# Rezoning Transportation Analysis

Petition Number: #2022-079

From: Jake Carpenter, PE

## Revision Log:

RZ - 200

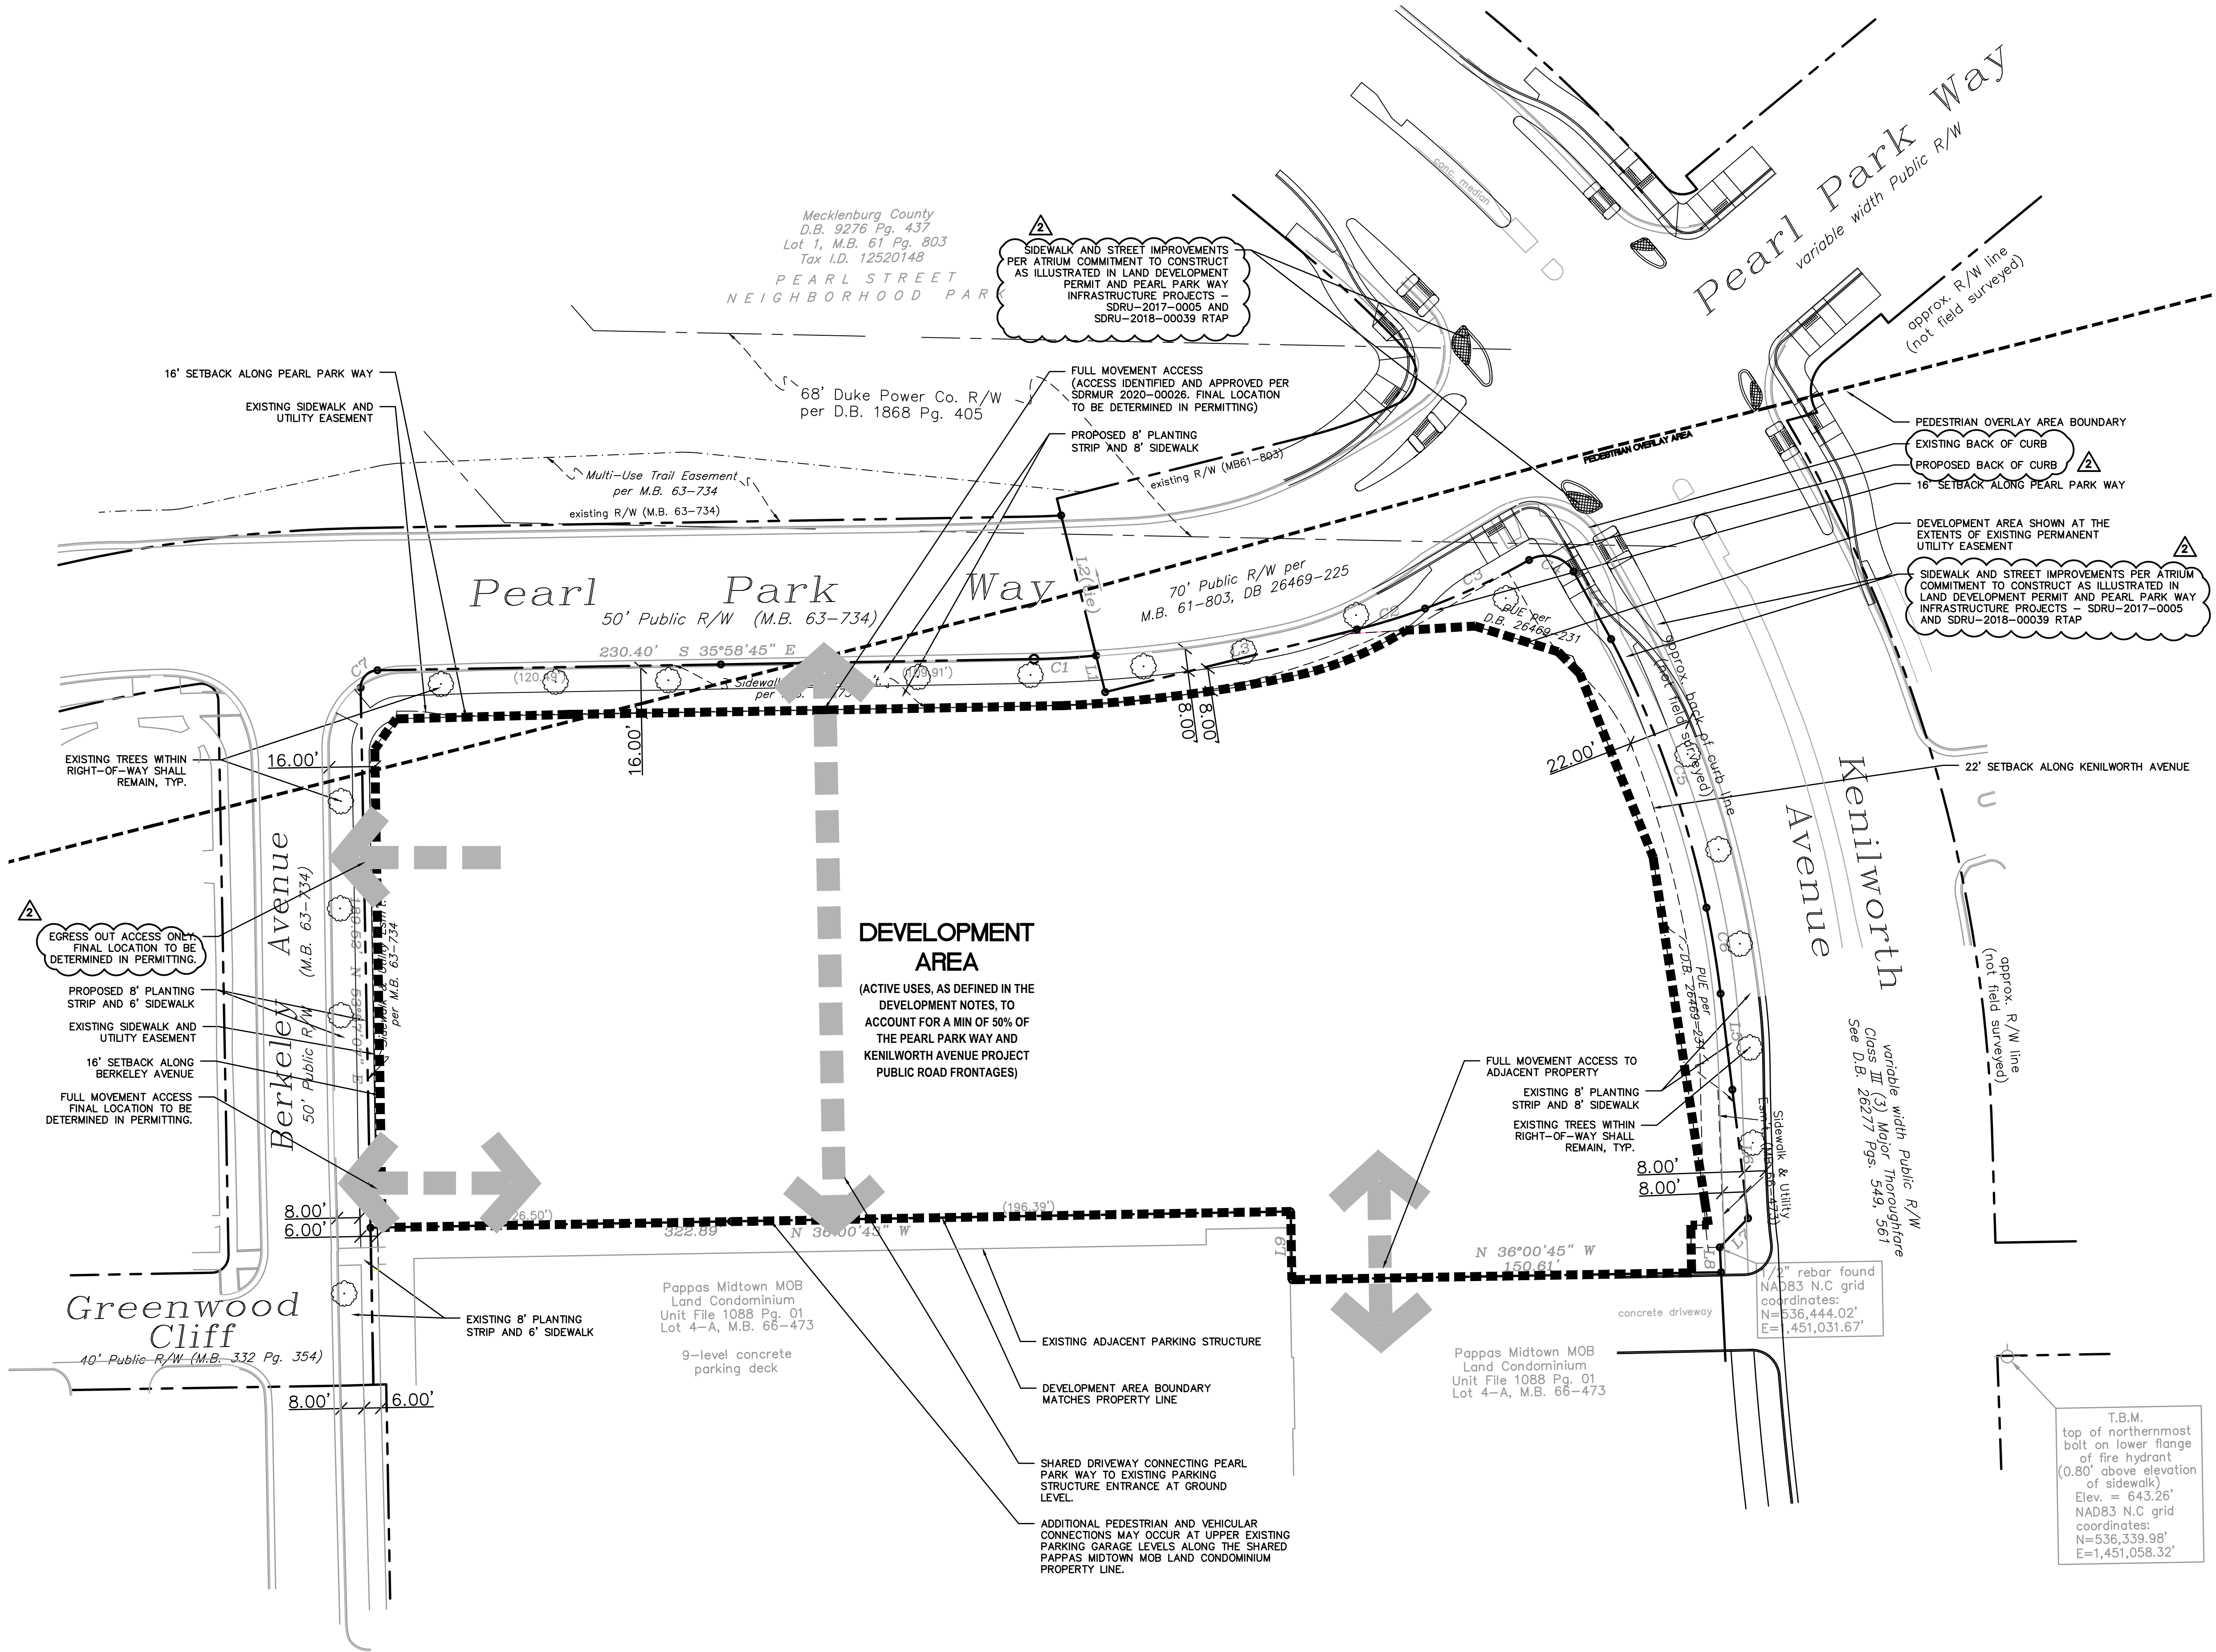
~~**Outstanding comment 12-22-22:** Label and dimension the curb and gutter from the centerline for each road on the site plan.~~

4. ~~Revise site plan and conditional note(s) to provide 8-foot sidewalk and 8-foot planting strip along the frontages of Kenilworth Avenue, Pearl Park Way, and Berkeley Avenue.~~

5. ~~**Outstanding Comment 11-28-22:** Revise site plan and conditional note(s) to commit to installing the protected intersection project at the intersection of Kenilworth Avenue and Pearl Park Way. Screen in the improvements for the project.~~

6. ~~**Outstanding Comment 12-22-22:** The two proposed driveways on Berkley Avenue do not meet the minimum 75-foot corner clearance distance from an unsignalized intersection per the *City of Charlotte Driveway Regulations*. The driveways will either need to be consolidated or one of them will be limited to right-in/right-out.~~

RZ - 200

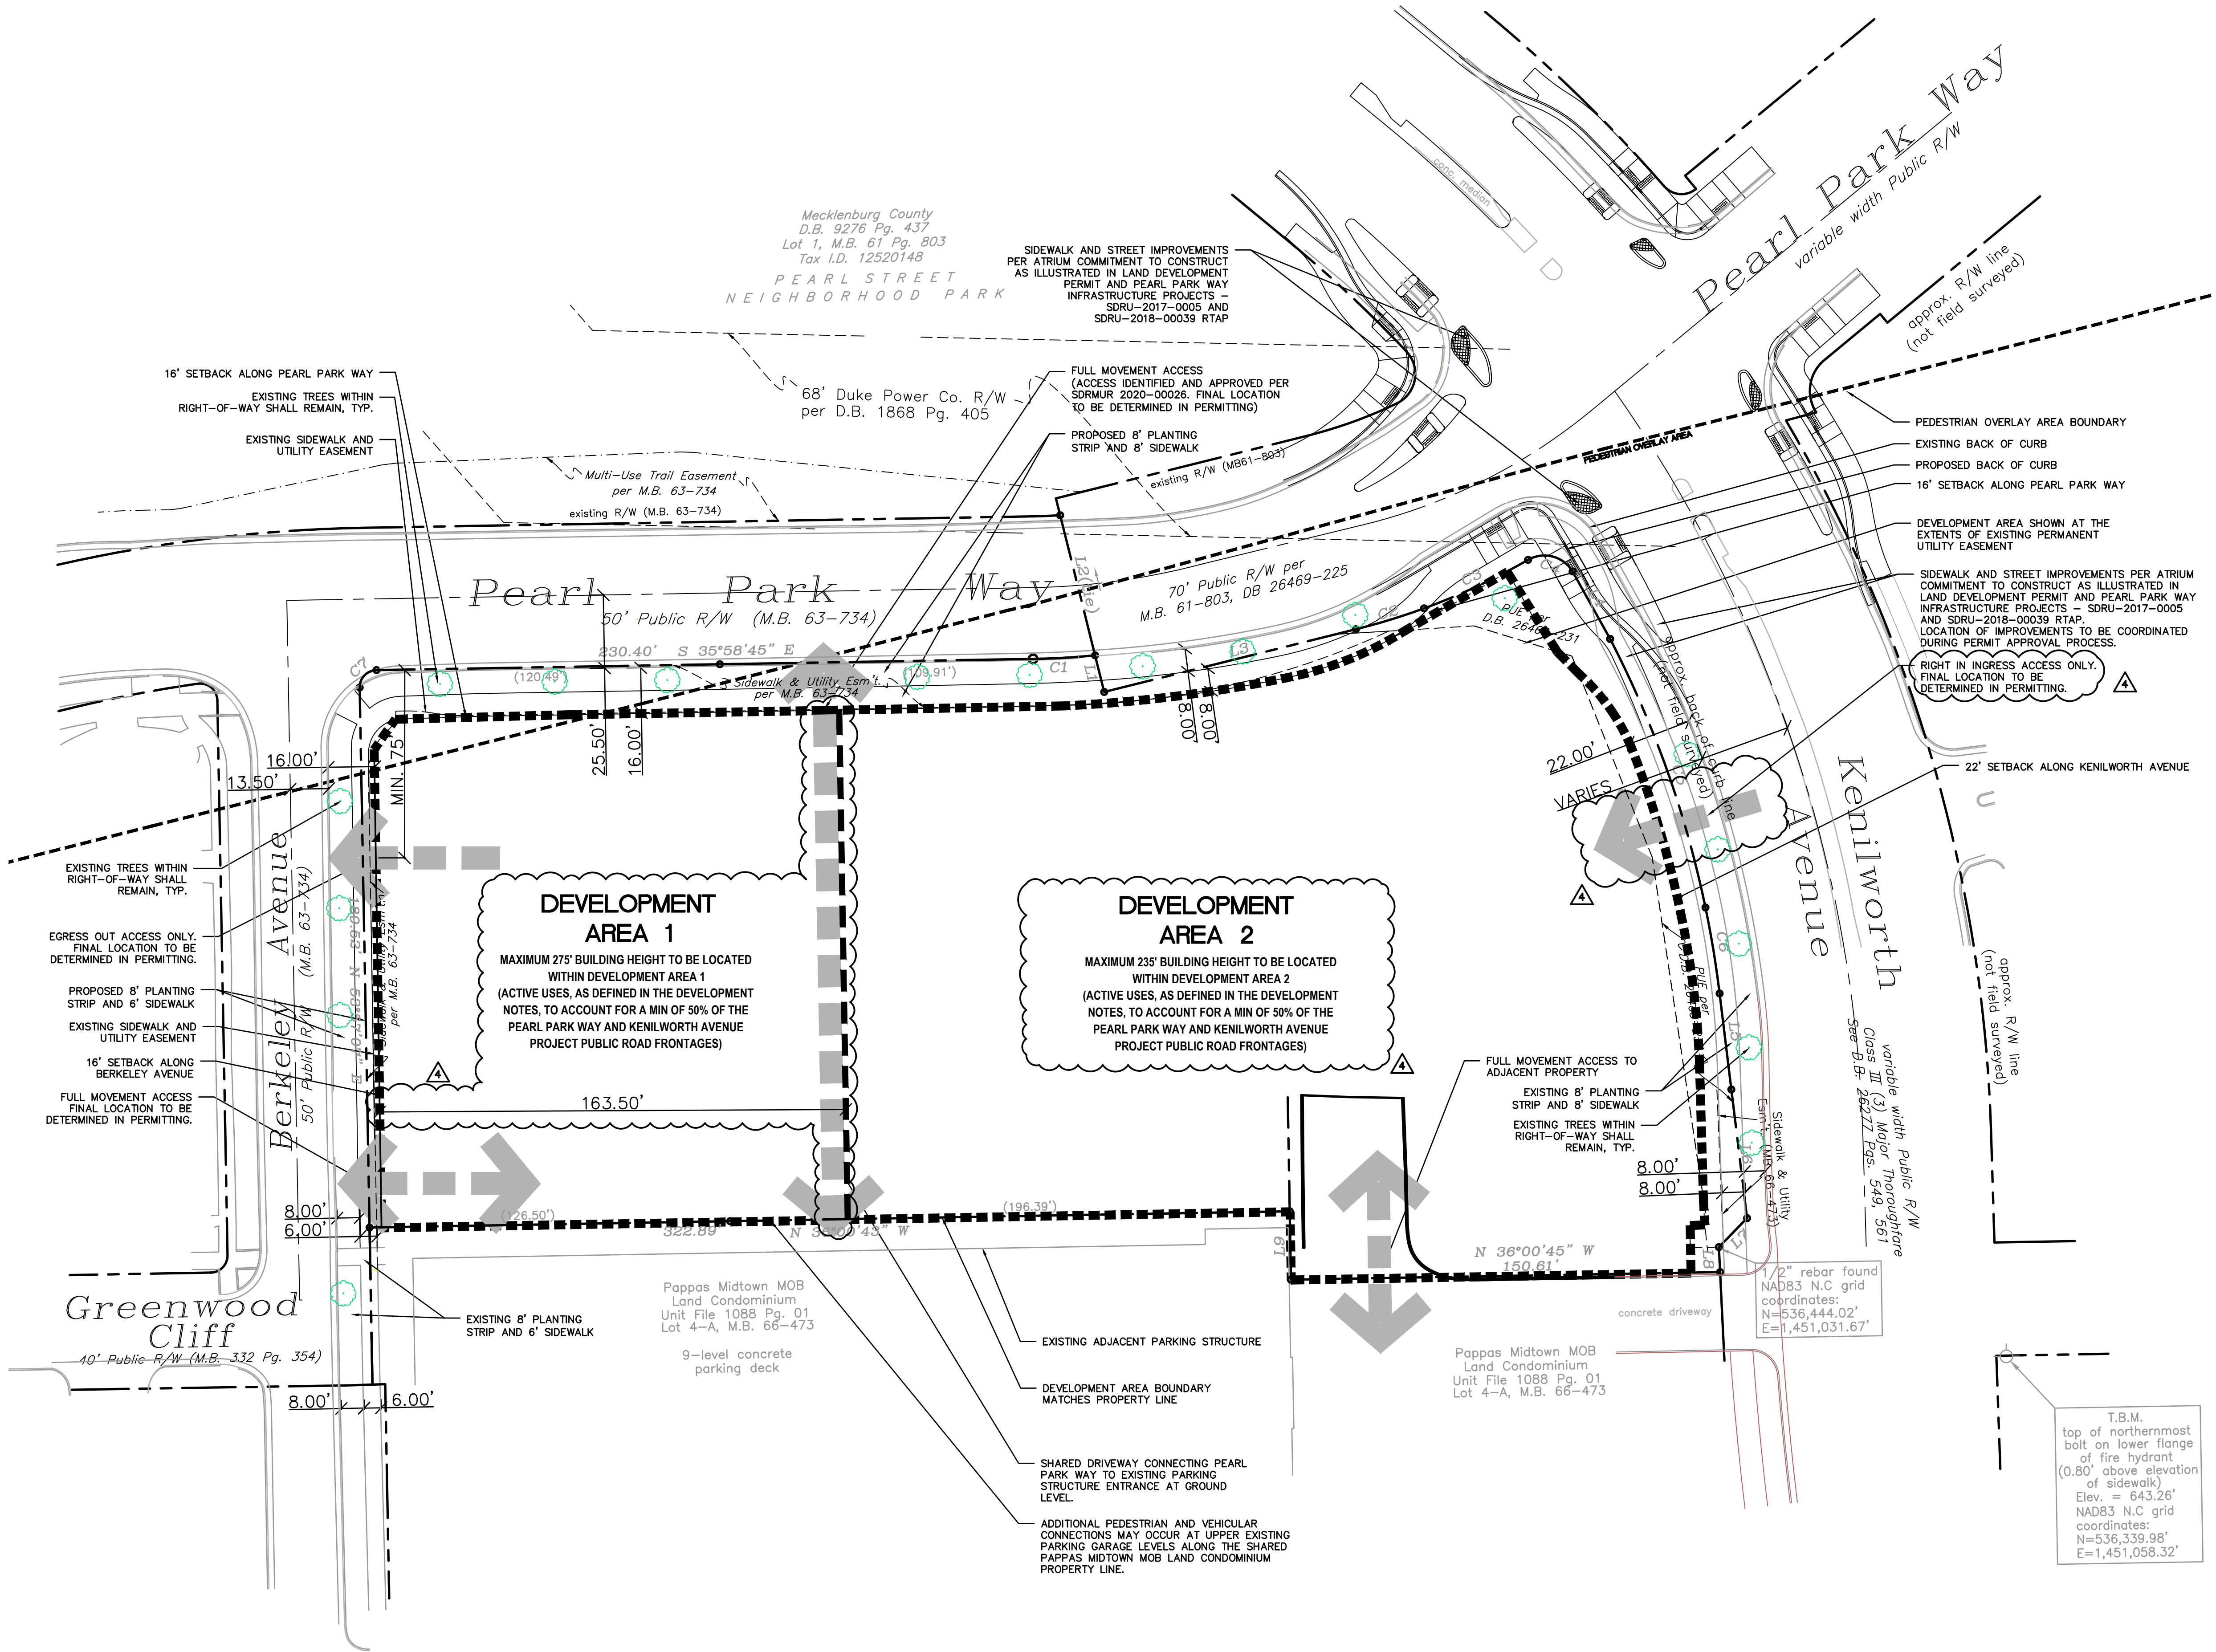
3. ~~**New Comment 11-27-23:** Revise site plan and conditional note(s) to remove the proposed right-in only access on Kenilworth Avenue. Access on Kenilworth Avenue does not meet driveway spacing requirements with respect to adjacent driveways, distance to signalized intersection, and conflicts with future protected intersection improvement. The site plan should be redesigned to access the site from Kenilworth using the established shared access point south of the petition.~~
